From: Plater, Roger - Communities <Roger.Plater@Oxfordshire.gov.uk>
Sent: 20 December 2021 11:01
To: James Kirkham
Cc: DC Support; Transport CDC Minor; Cllr Arash Ali Fatemian
Subject: 21-03947-F Cotefield House Oxford Road Bodicote

Planning application: 21/03947/F
Location: Cotefield House Oxford Road Bodicote OX15 4AQ
Description: 5 attached two bedroom houses, parking and amenity spaces - re-submission of 21/01835/F
Type: Full Application
Case Officer: James Kirkham

Oxfordshire County Council, as the Local Highways Authority, hereby notify the District Planning Authority that they **object** to the granting of planning permission

Plan referred to in the Conveyance  
 dated the *2nd* day of *December* 1961 and made between the  
 W.V.S. Housing Association of the one part and the Oxfordshire  
 County Council of the other part.

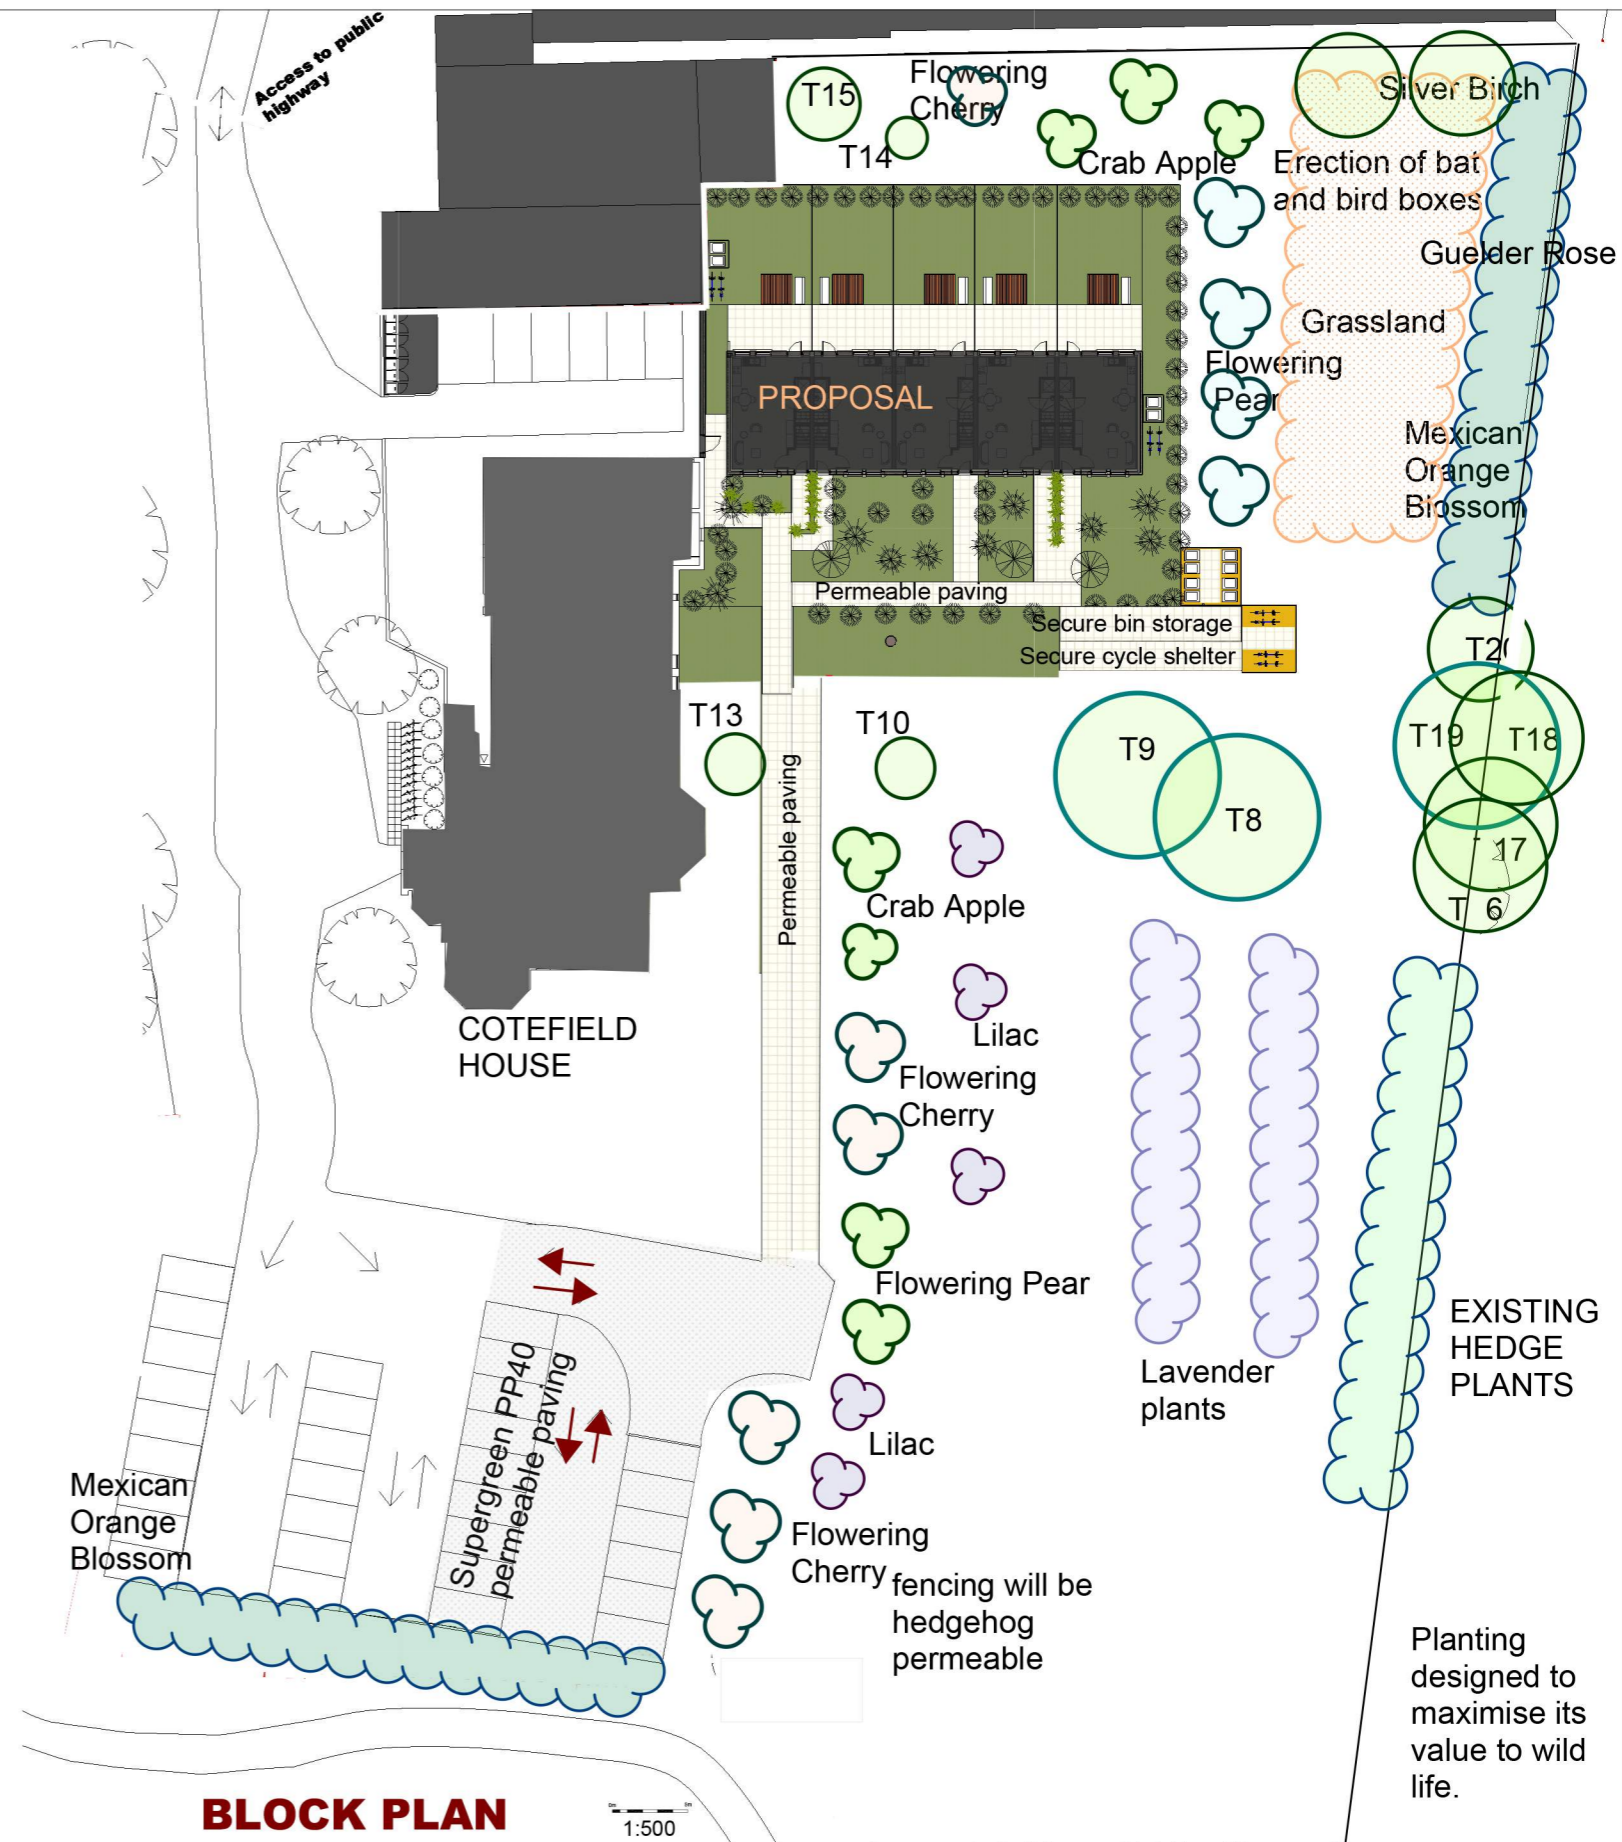
The plan in the Deed does not have a scale indicated. By my estimation, which is based on the length of Cotefield House as it is shown in both the Deed plan and the Site Location Plan, is that the width of the track shown in yellow on the Deed plan is closer to 4.7m. There is clearly some doubt about the precise width of the access track/road, but this is not crucial for my recommendation as I am happy that it is wide enough for two vehicles to pass. If the application is to be approved, it should be conditioned that the access track (width to be agreed by applicant and landowner) is clearly delineated by signing and lining and/or surfacing, prior to commencement of construction. As well as defining the agreed extent of the route on the ground, this will help to highlight the possible presence of pedestrians and cyclists to drivers traversing the yard.
